Please ask for: Mrs D Johnson
Email: daun.johnson@arun.gov.uk
Telephone: 01903 737762
Our Ref: BR/188/21/CLP
Your Ref:
Date: 3rd August 2021

Lawful Development Certificate for a Proposed Use or Development

Development: Lawful development certificate for the proposed change of use of garden shed to salon.
Location: 11 Hampton Court Bognor Regis PO21 5SS

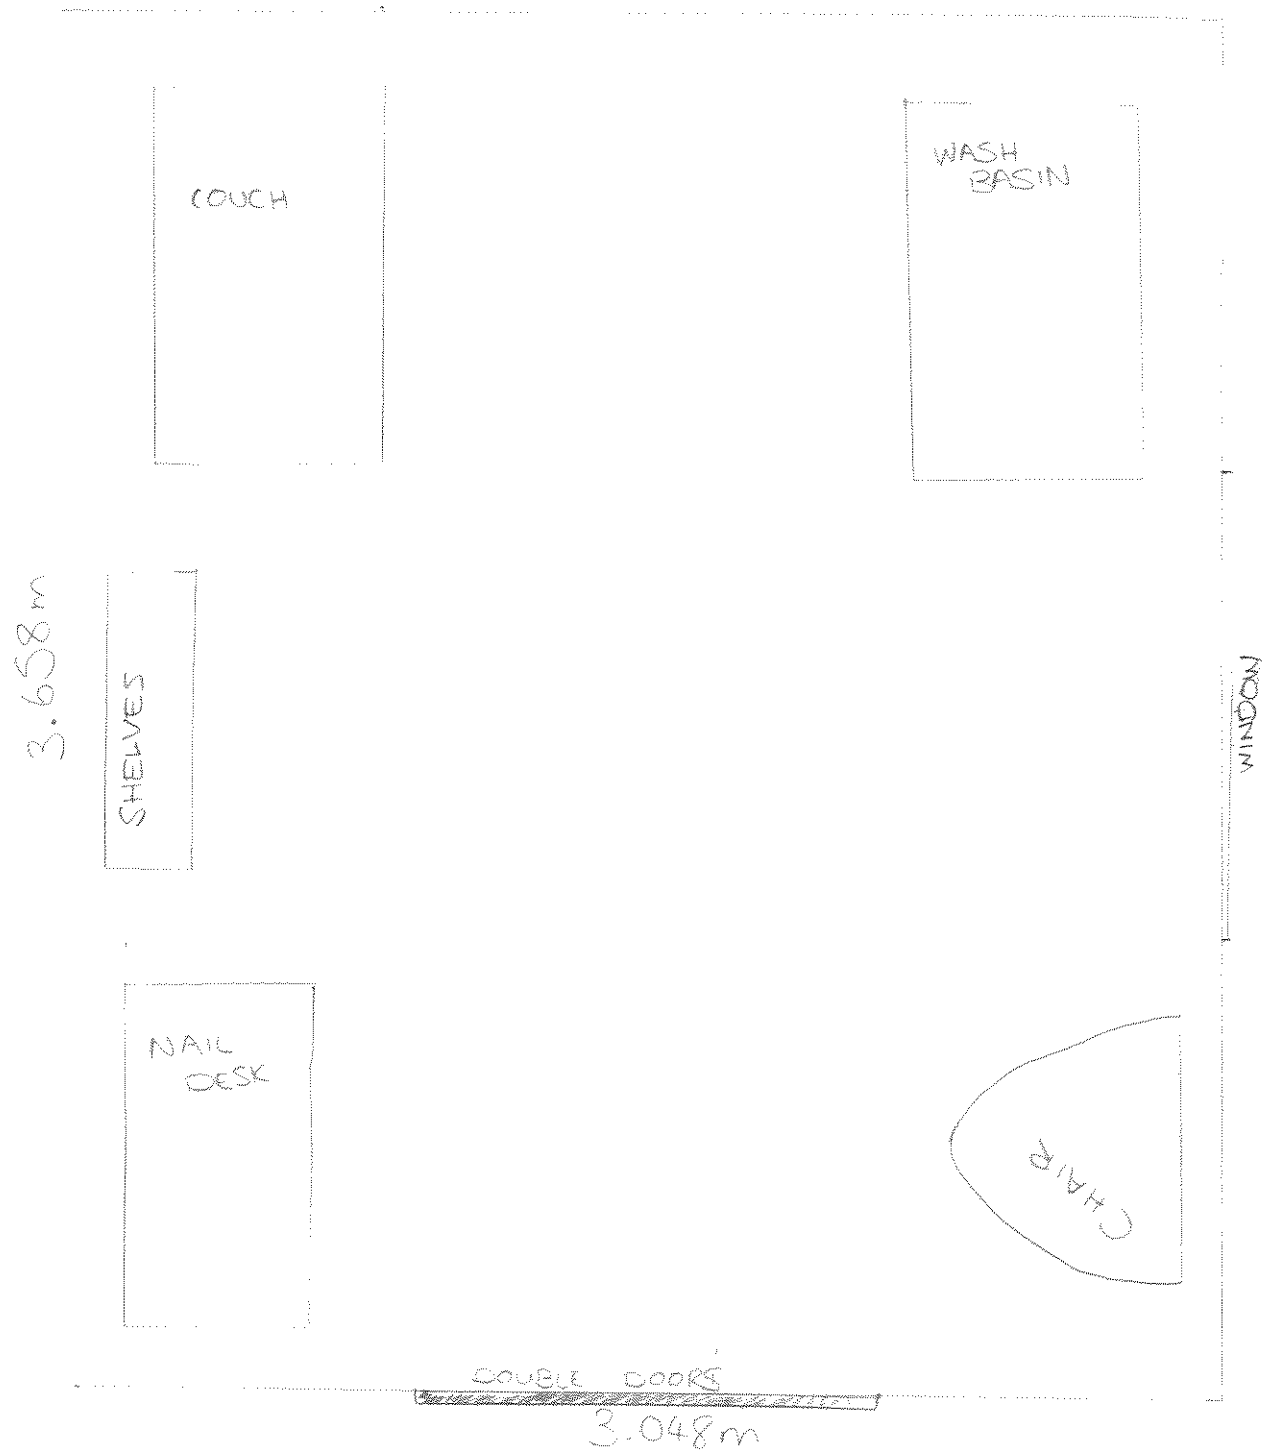
The plan received does not have the entire shed as one wall is missing.

Please provide all measurements on the floor plan in metric.

If there are windows on the shed, please indicate these on the floor plan.
